NEW RESTAURANT FOR:  
**ARBY'S - INSPIRE DUAL HIGH 40 - STD**  
11775 MERIDIAN MARKET VIEW  
FALCON, CO  
FOR  
RB AMERICAN GROUP  
6200 OAK TREE BLVD, INDEPENDENCE, OH 44131

SITE  
PHOTOMETRIC  
PLAN

E0.1

**E0.1**

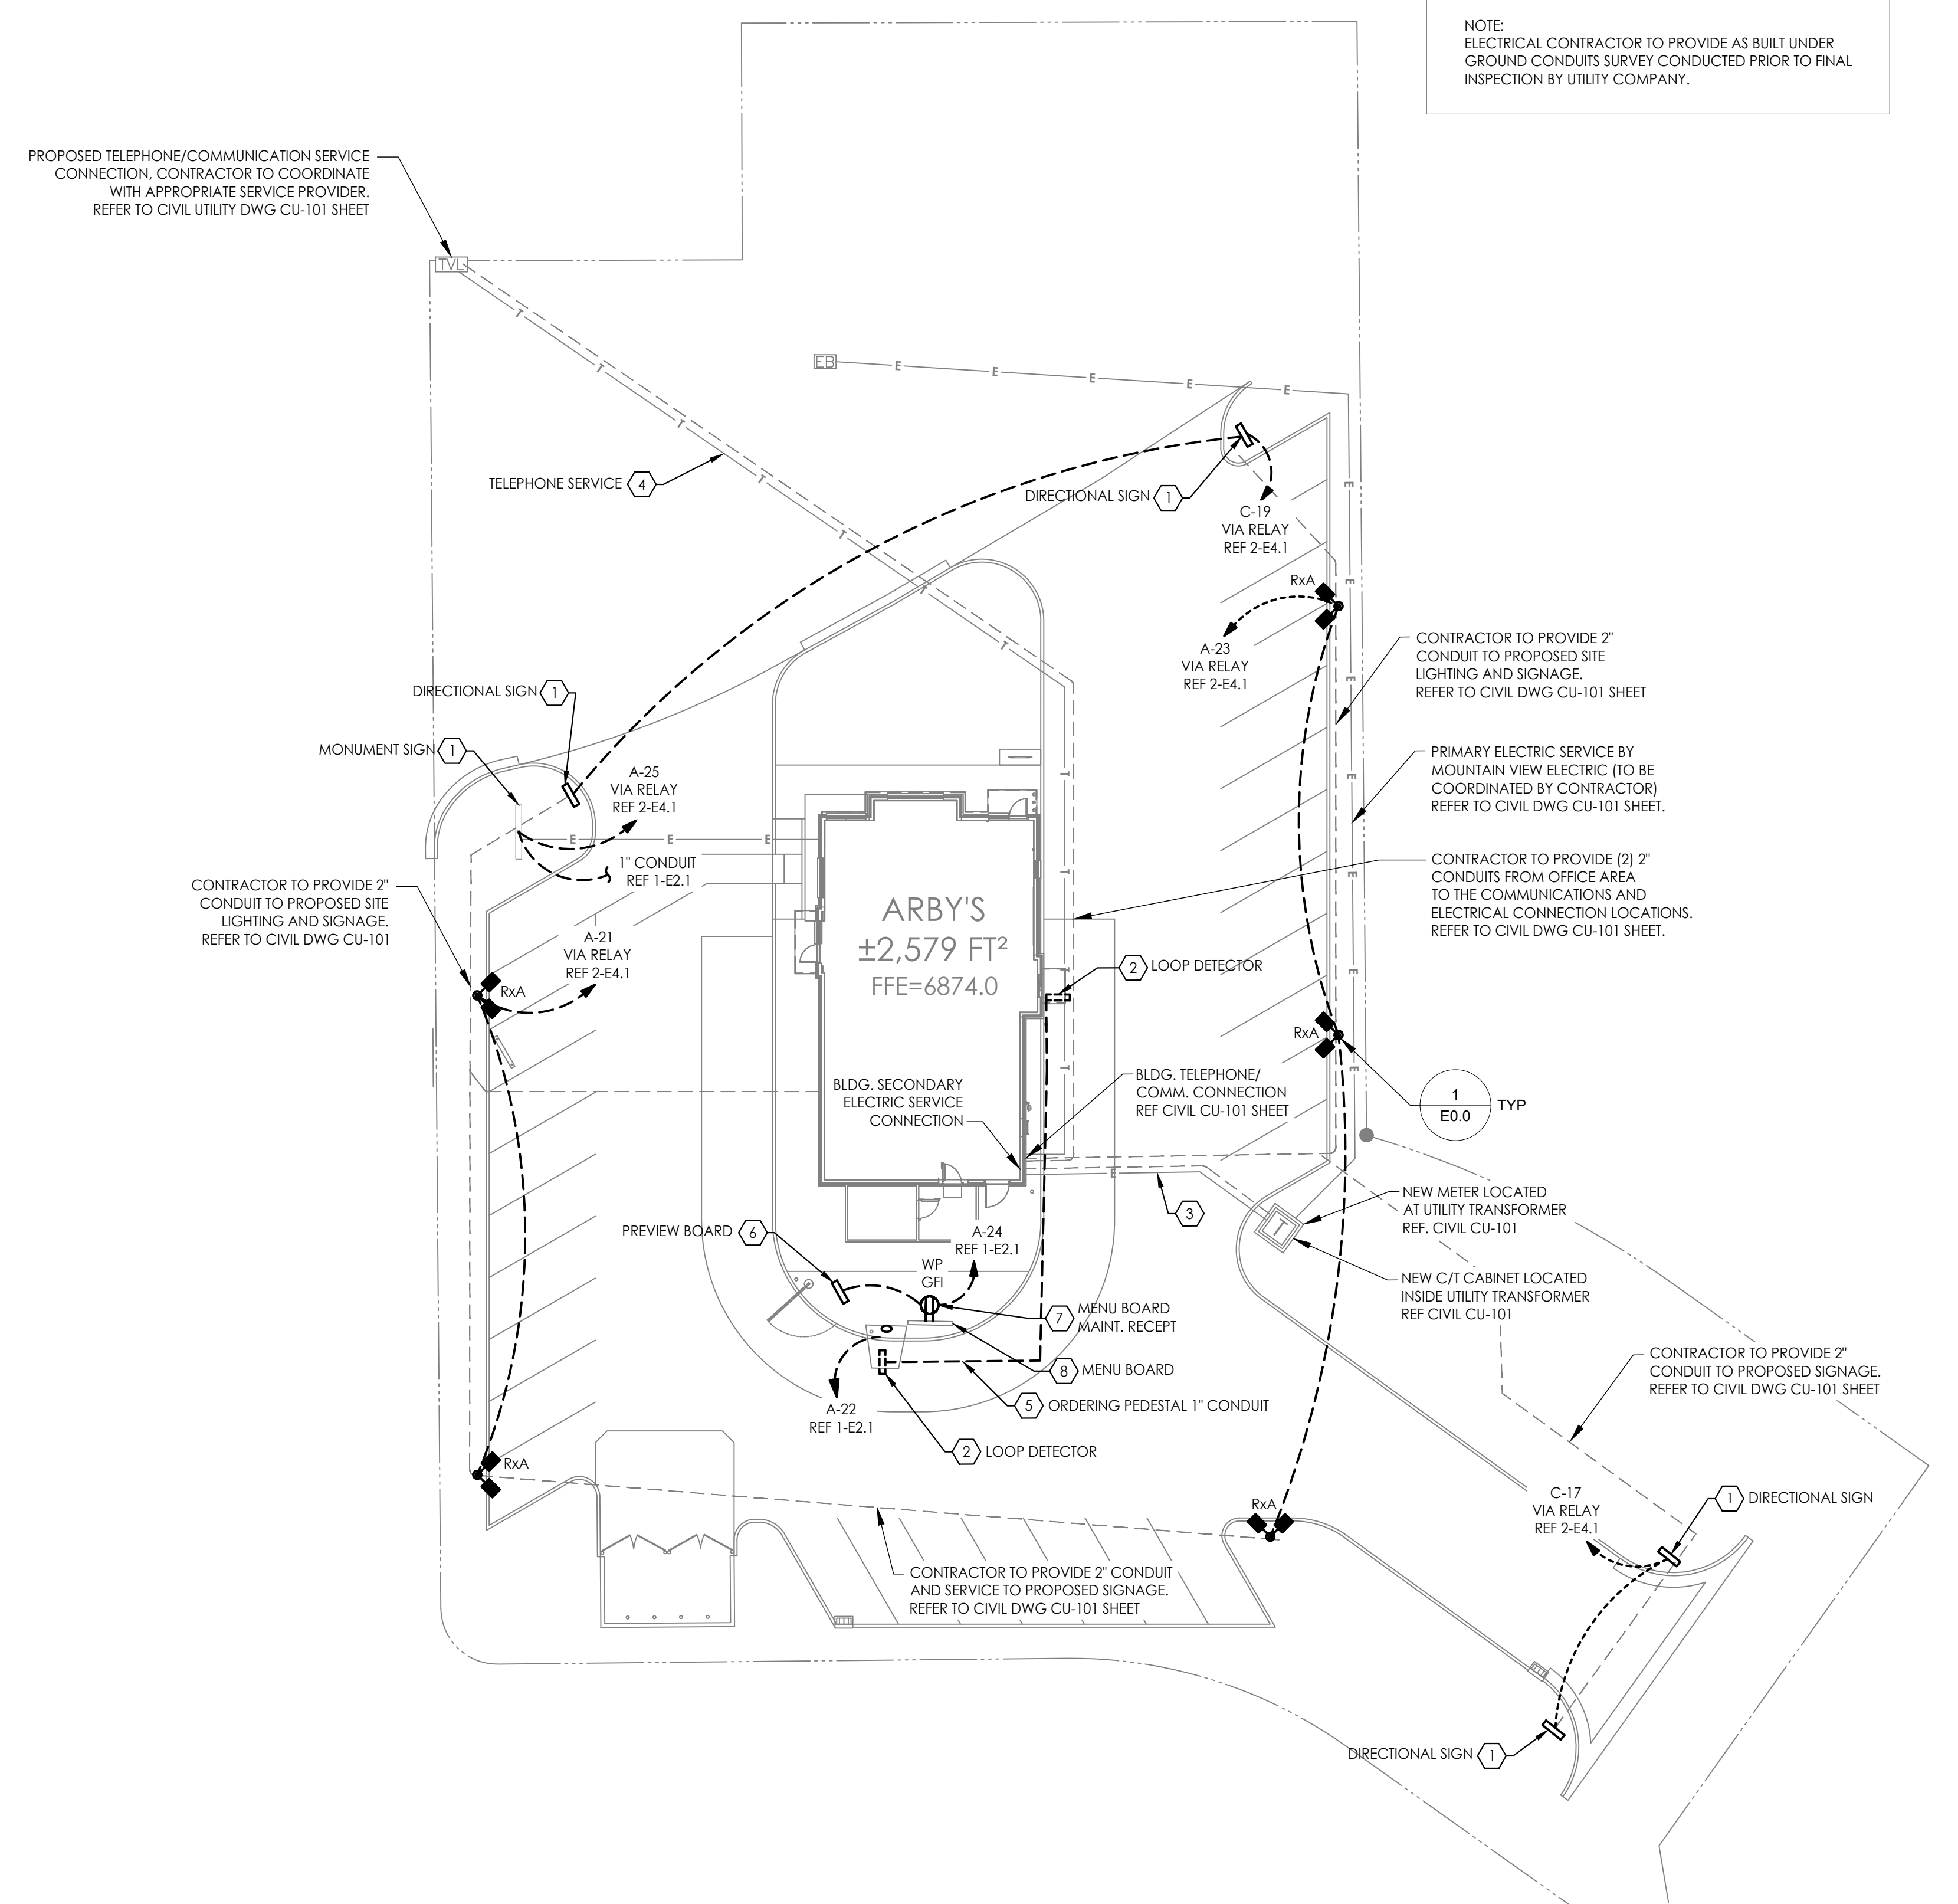
Highlighted areas are still exceeding the foot candle limit of 0.1 along roadways. Please revise and resubmit.
